CITY OF ALBUQUERQUE

January 23, 2020

**Re: T616 Lomas
616 Lomas Blvd NW
30-Day Temporary Certificate of Occupancy
Transportation Development Final Inspection
Engineer's/Architect's Stamp dated 7-25-17 (J14D183)
Certification dated 1-17-20**

SHEET NO:
A1.1

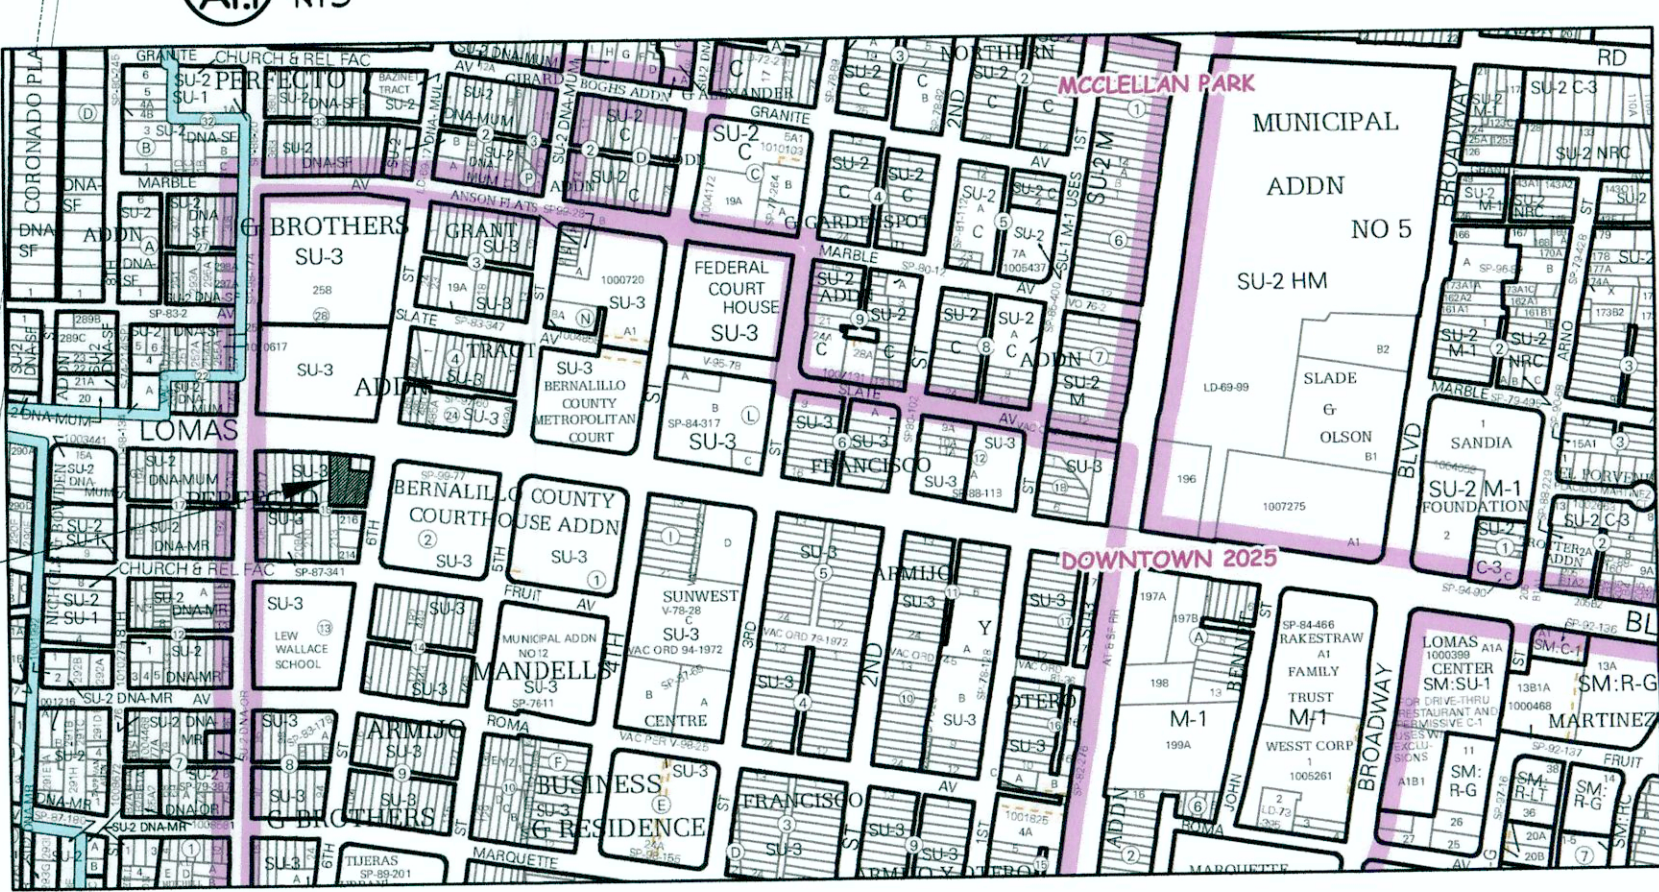
- Please add Truncated Domes. All wheelchair ramps located in the public right of way must have truncated domes.
